**WELWYN HATFIELD BOROUGH COUNCIL
EXECUTIVE DIRECTOR - PLANNING, PUBLIC PROTECTION AND GOVERNANCE**

Application No: 6/2022/0893/HOUSE
Location: 1 Stonecross Road Hatfield AL10 0HR
Proposal: Erection of a single storey, part two storey rear extension
Officer: Ms Kirsty Shirley

Recommendation: Refused

Dwg. No. **HET 1682/03**
Rev. -

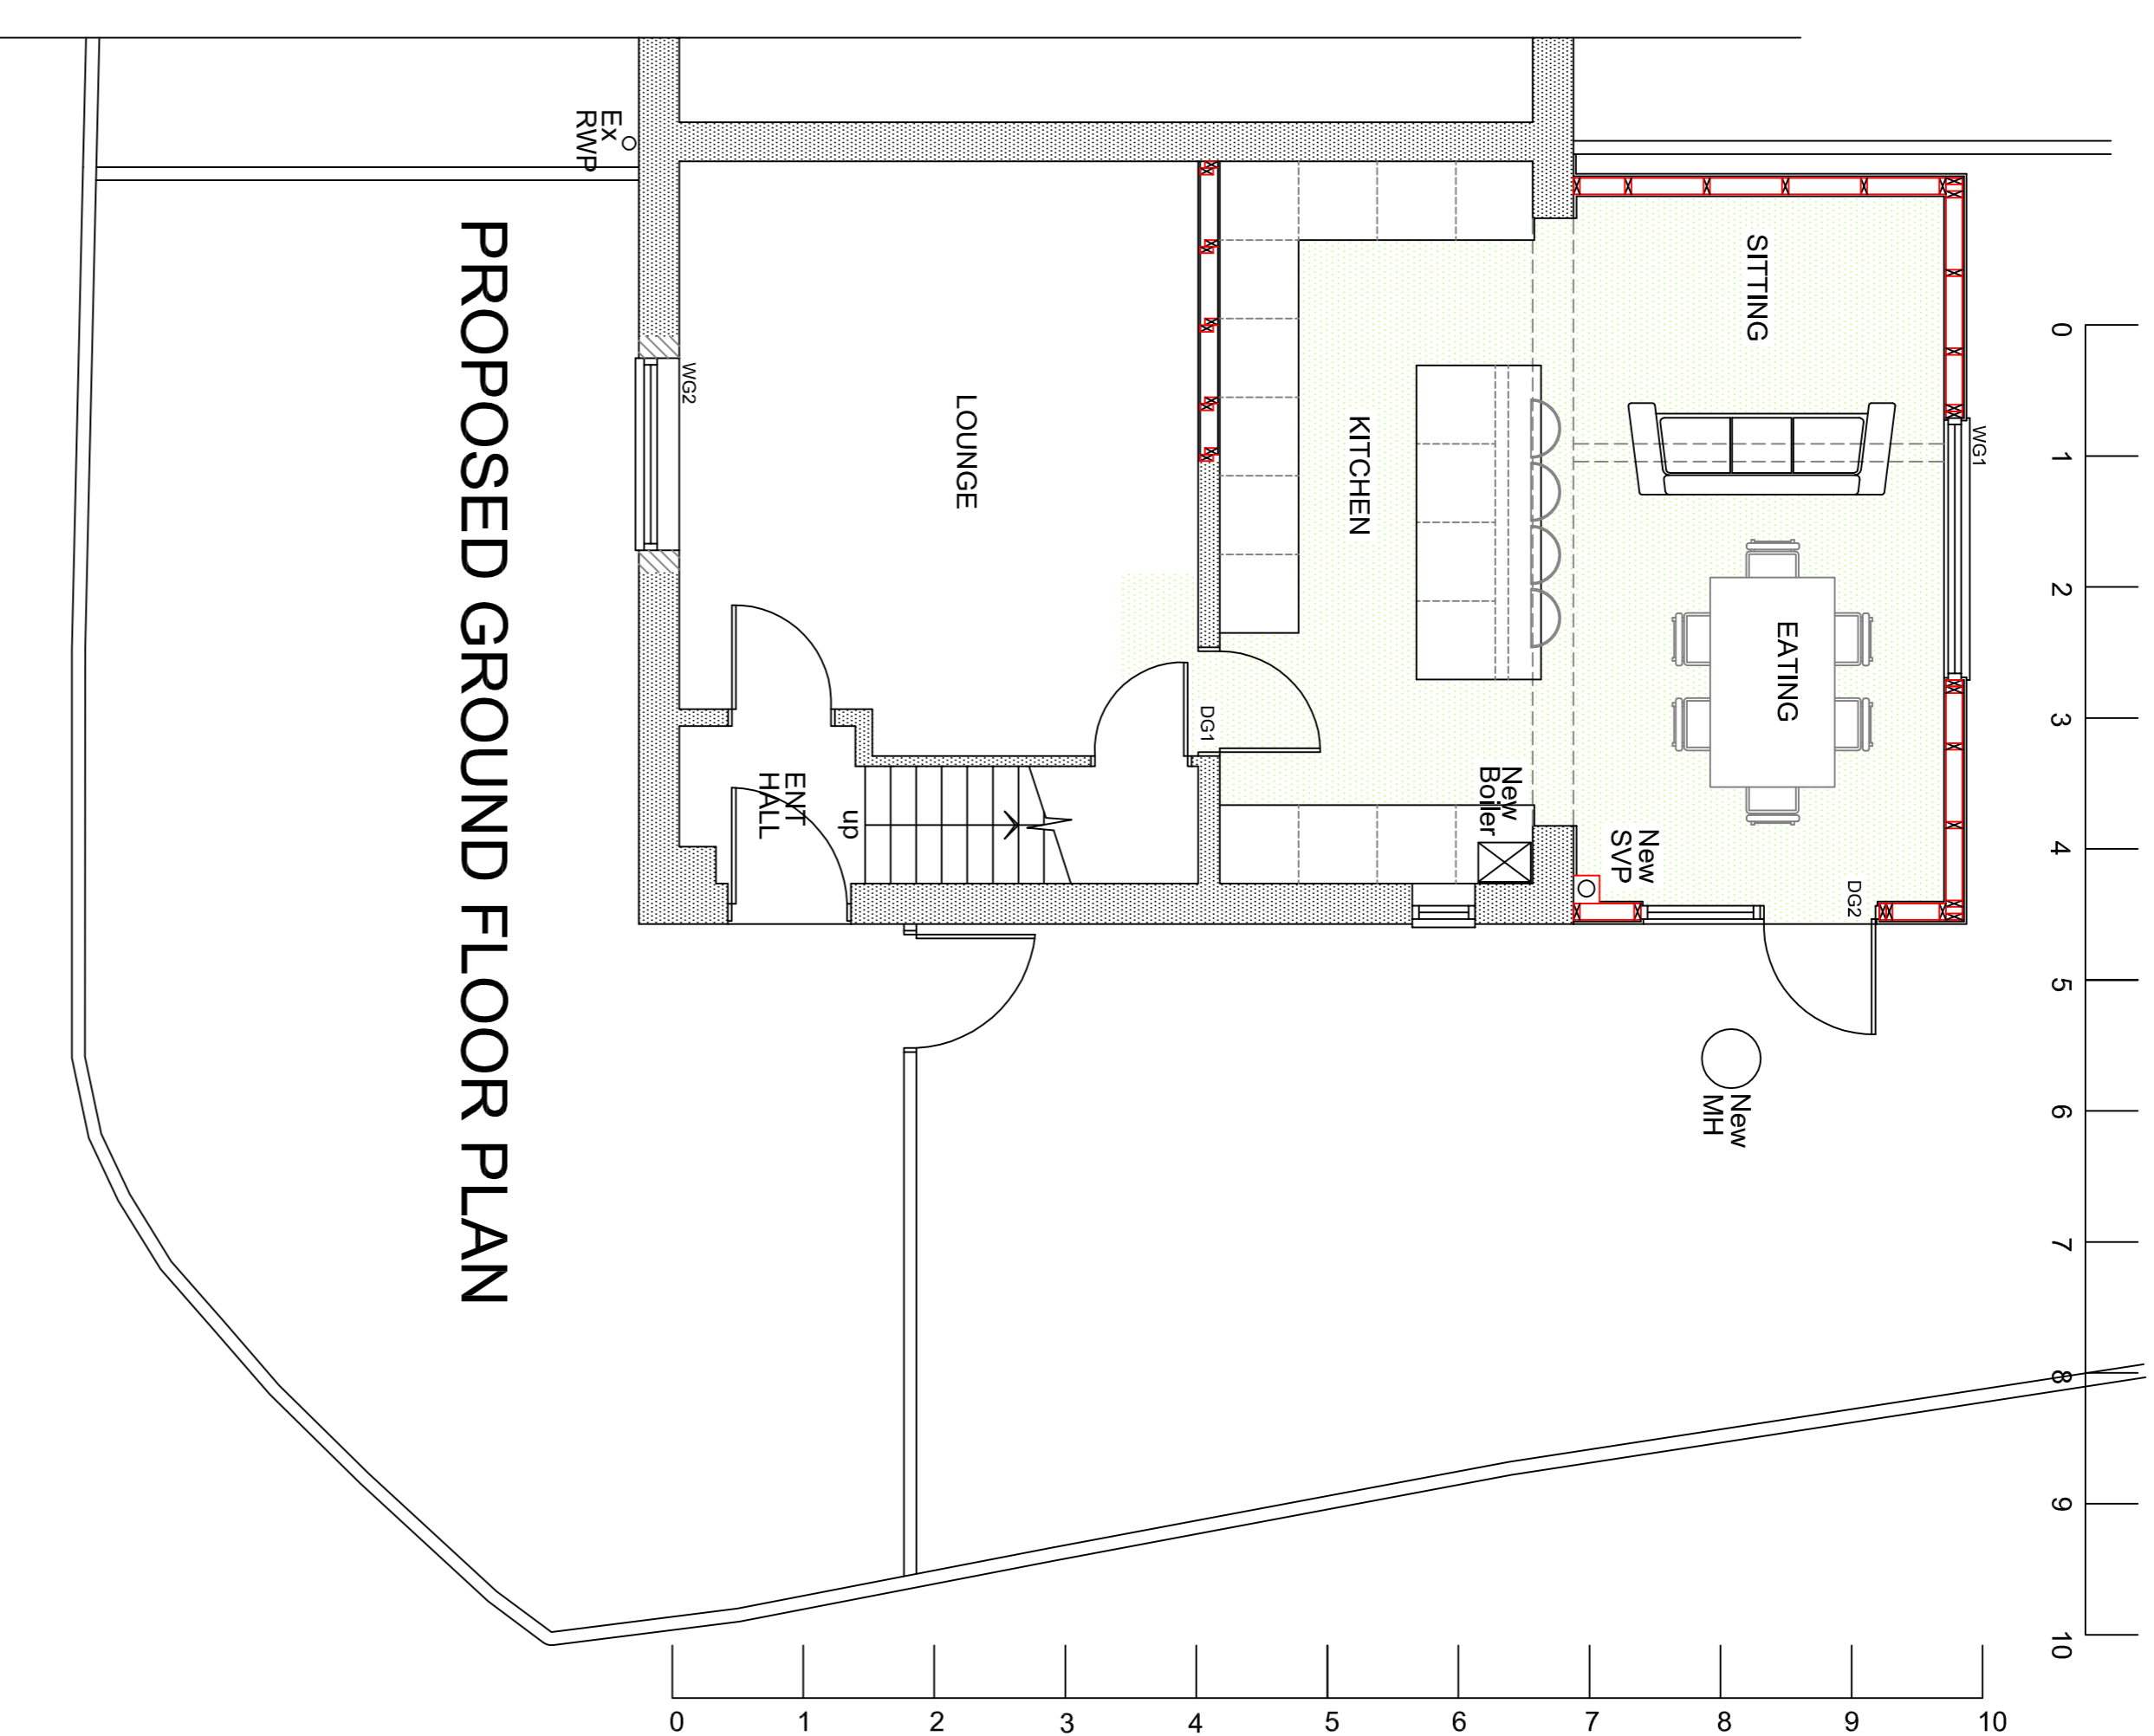
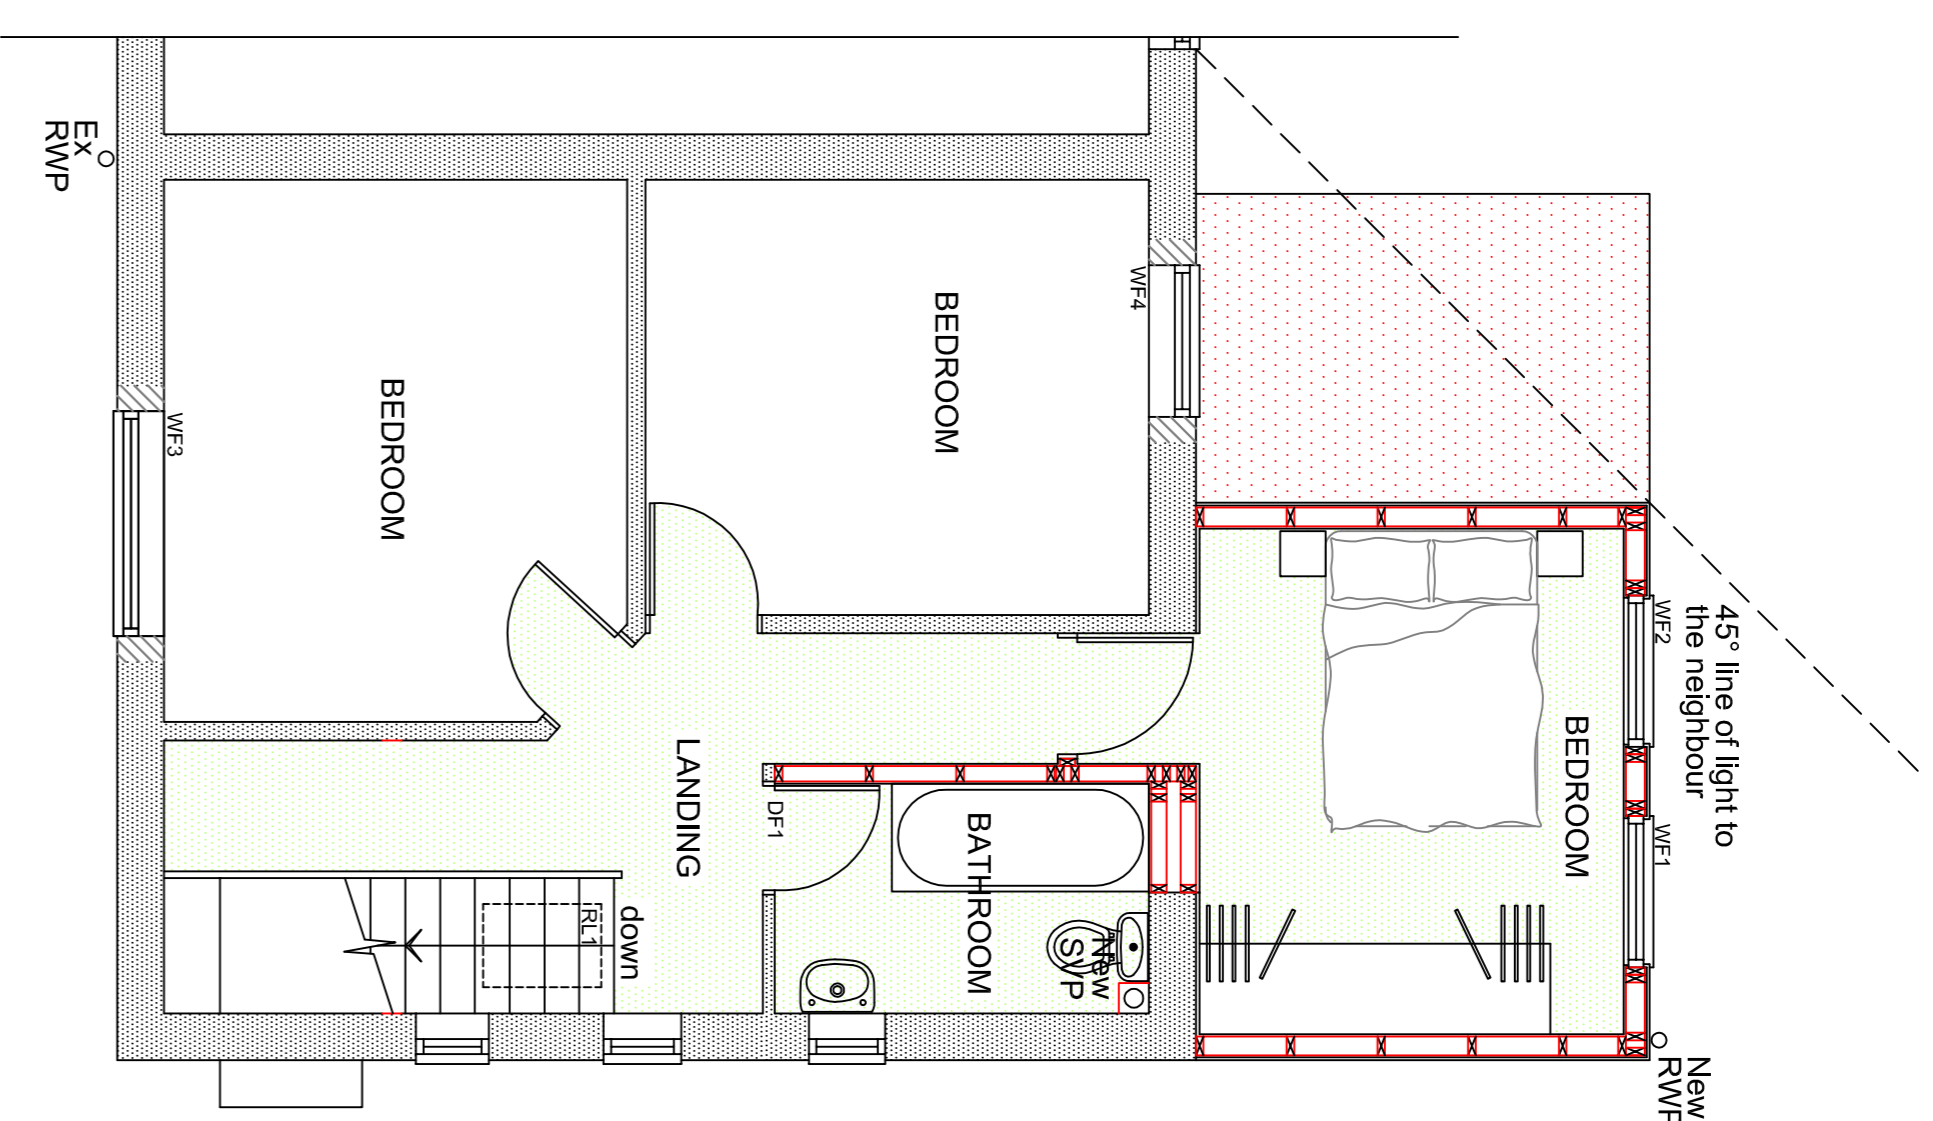
<p>developments bulk and massing. The eaves to the left side of the proposed gable roof when viewing the dwelling from the rear would also extend beyond the existing eaves of the dwelling. The existing eaves project outwards from the front and rear elevations of the dwelling in a form that this is replicated at each end of terrace dwelling in the four blocks of dwellings located to the north side of Stonecross Road. The proposal would therefore interrupt this uniformity in the eaves and would consequently detrimentally detract from the character of both the application dwelling and wider area.</p> <p>It is therefore considered that the proposed development would represent a poor standard of design, contrary to District Plan Policies D1 and D2; the Supplementary Design Guidance; and the National Planning Policy Framework.</p>
Impact on neighbours	<p>No neighbour representations have been received.</p> <p>No windows would be inserted into the first floor side elevations of the extension, protecting the privacy of the occupiers of No.2 Stonecross Road. A ground floor window would be inserted into the side elevation facing Ground lane and two windows would be inserted into the first floor rear elevation. No dwellings adjoin the application site to the rear or flank elevation and so these windows would not result in any harmful overlooking.</p> <p>The properties to the north side of Stonecross road have rear gardens that face north east, experiencing sunlight from the mid-afternoon onwards. The position and scale of the dwelling would not result in adjoining neighbour No. 2 Stonecross Road to experience a detrimental loss of sunlight. Similarly, the positioning, size and scale of the dwelling would not appear overbearing or unduly dominant towards the adjoining neighbours of No. 2 Stonecross Road.</p>

1. By virtue of the size, scale, positioning and design of the proposal, the proposed development would represent a poor standard of design, contrary to District Plan Policies D1 and D2; the Supplementary Design Guidance; and the National Planning Policy Framework.
